**Rezoning Transportation Analysis**  
**Petition Number: Insert Zoning Petition #2022-076**  
*General Location Identifier: 13317113*

**Revision Log:**

Date	Description
10-26-22	First Review (IW)

REZONING
CONCEPTUAL
SITE PLAN

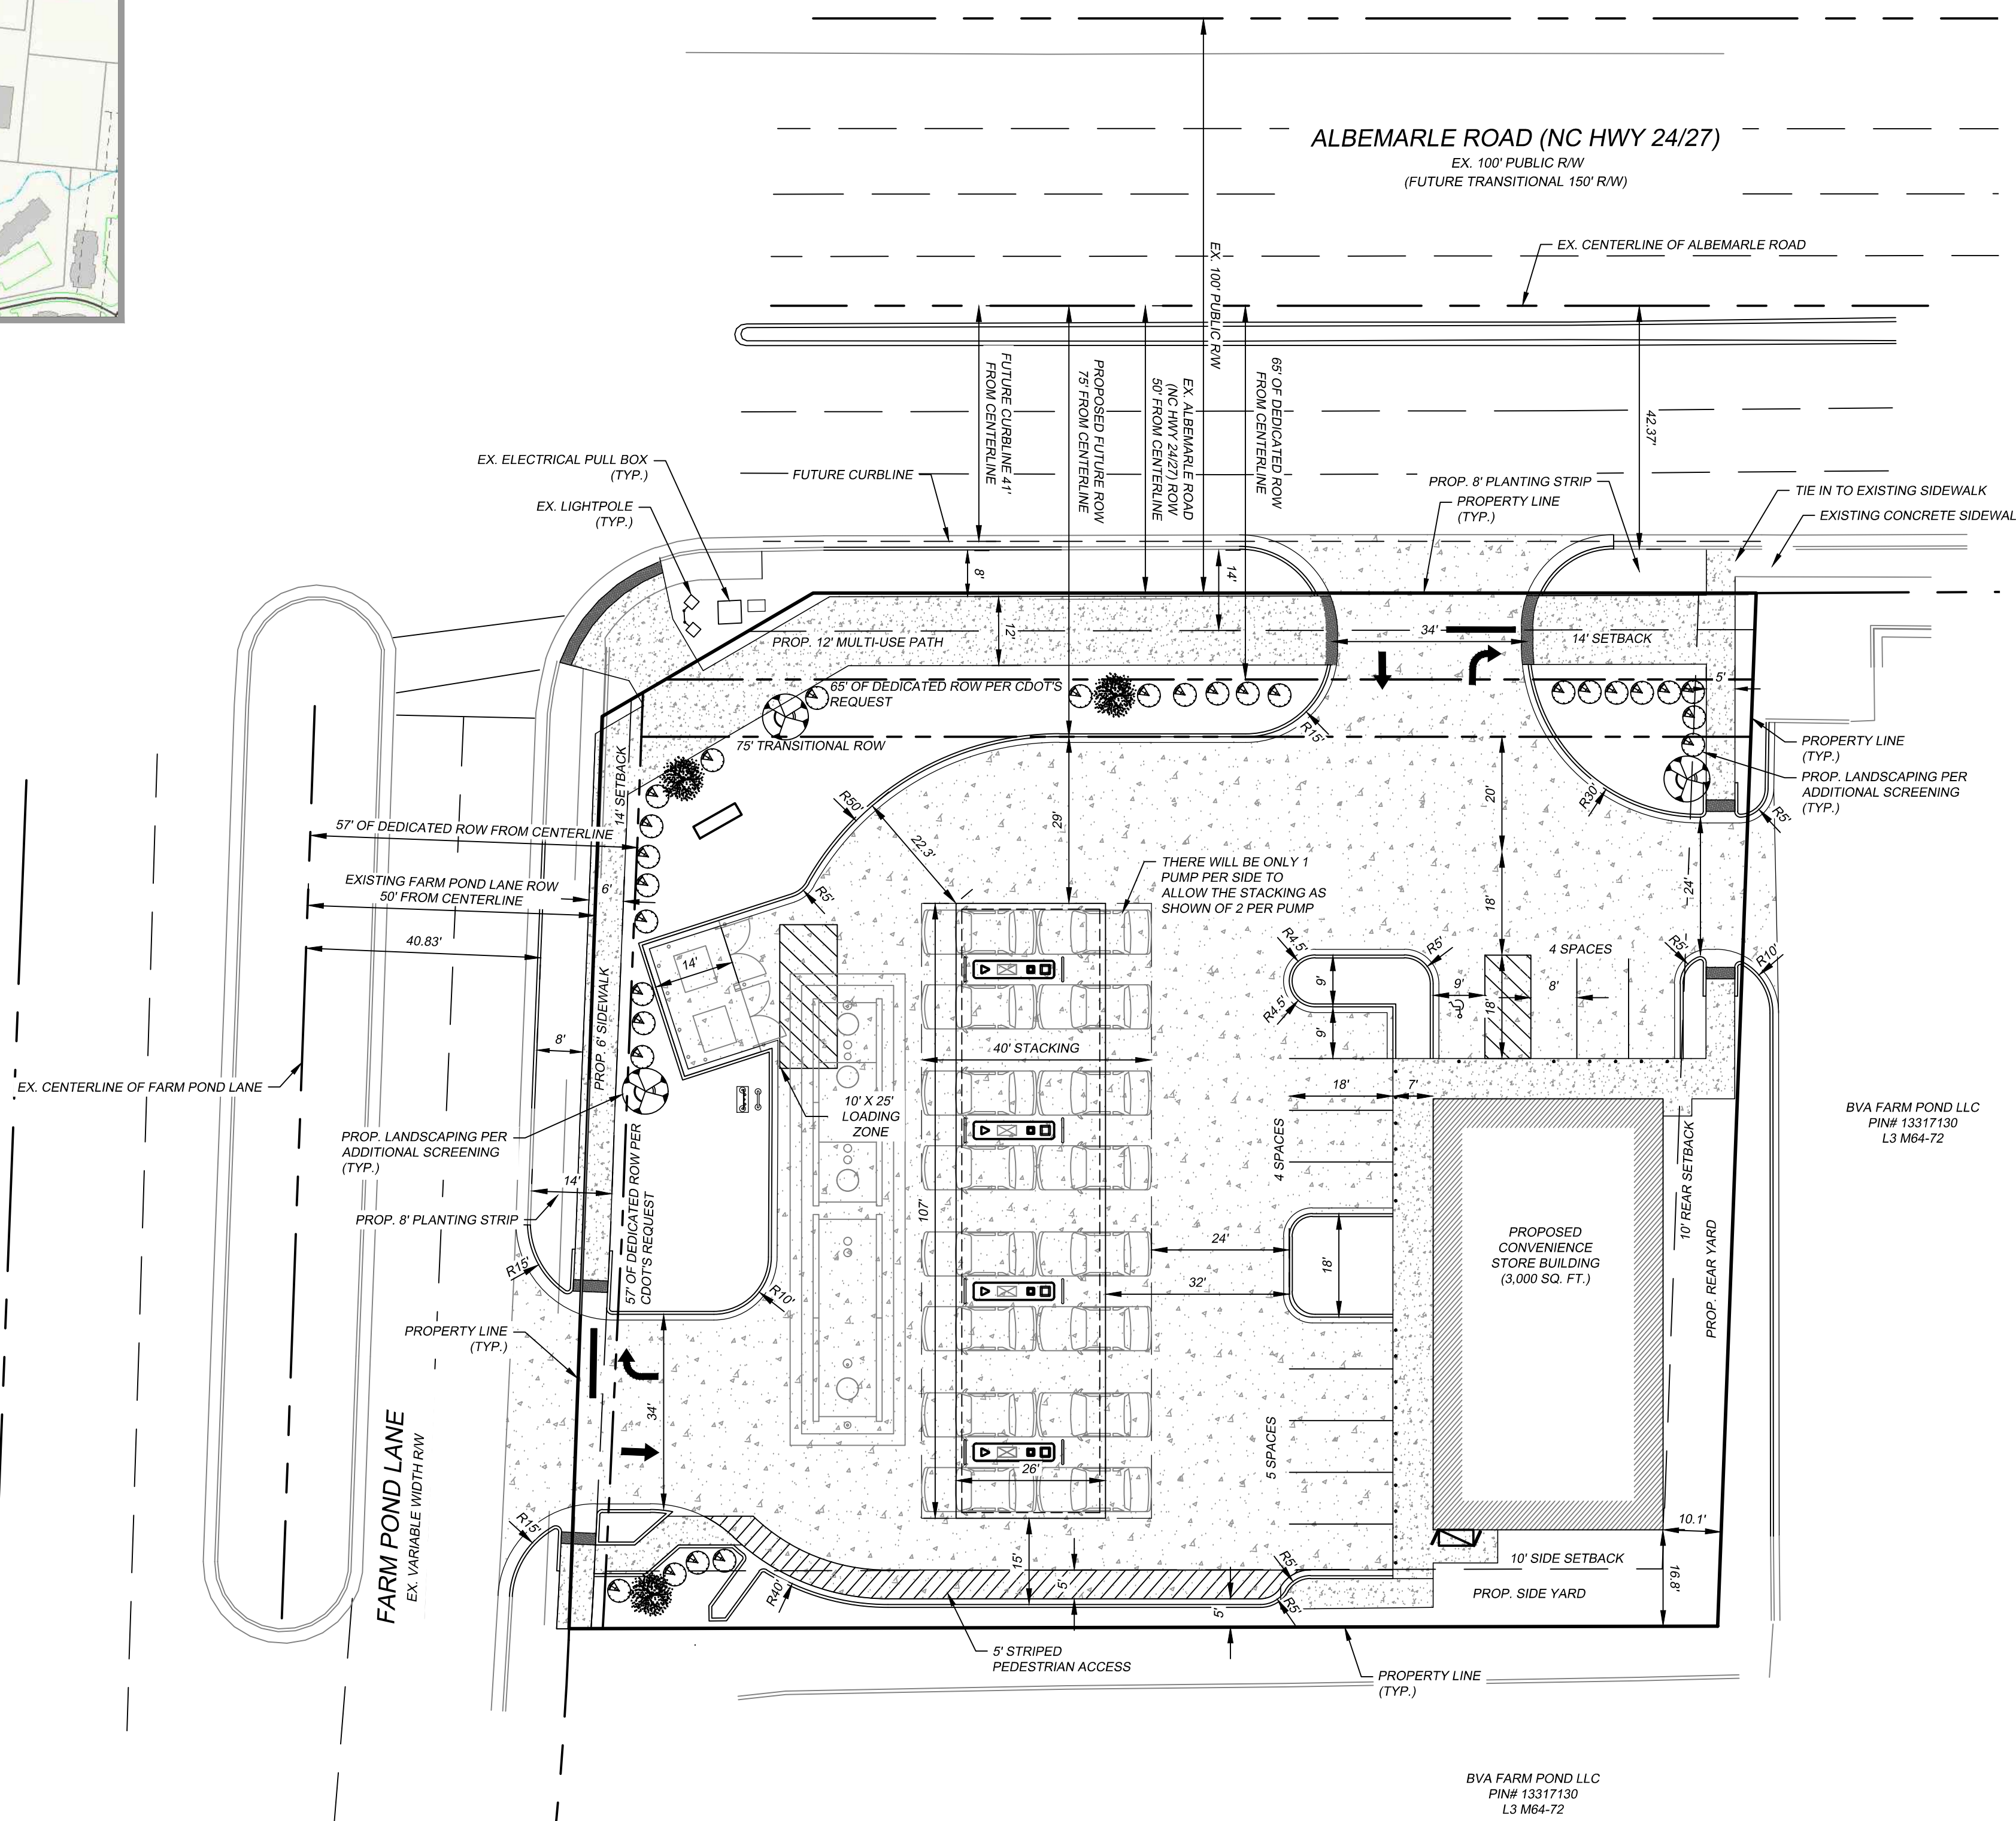
1. **Curblines:** The proposed zoning district has a setback measured from back of the existing or proposed future curblines.
  - a. **Albemarle Road:** Future curblines location: 41' from centerline of Albemarle Road
  - b. **Farm Pond Ln:** Maintain existing curblines

Label and dimension the curb and gutter from the centerline for each road on the site plan.

3. Revise site plan and conditional note(s) to commit to dedicate 63' right-of-way from the road centerline on Albemarle Road (or 2' behind proposed 12-foot multi-use path). Revise site plan to label and dimension existing right-of-way from centerline of Farm Pond Lane and/or committing to dedication of right-of-way set 2' behind proposed sidewalk where feasible.

The site plan shall label and dimension the right-of-way from the road centerline for both roadways.

4. Revise site plan and conditional note(s) to commit to construct an 8-foot planting strip and 6-foot sidewalk on Farm Pond Road per Chapter 19. Revise site plan and conditional note(s) to commit to construct an 8-foot planting strip and 12-foot Multi-Use Path on Albemarle Road per Chapter 19 and the city council adopted future Charlotte Streets Map.

The site plan shall label and dimension both items from the back of curb and gutter and road centerline.

5. Petitioner to revise site plan and conditional notes to show and commit to improving ramps at their corner of Albemarle Road and Farm Road Lane to comply with ADA/PROWAG standards. Per federal ADA guidelines, ramps should match width of sidewalk. 12-feet on Albemarle and 6-feet on Farm Pond Road.
6. A site plan note(s) specifying dedication and fee simple conveyance of all rights-of-way to the City before the site's first building certificate of occupancy is issued as needed. CDOT requests rights-of-way set at 2' behind back of sidewalk where feasible.
7. A site plan note specifying that all transportation improvements will be approved and constructed before the site's first building certificate of occupancy is issued as needed. The petitioner may phase
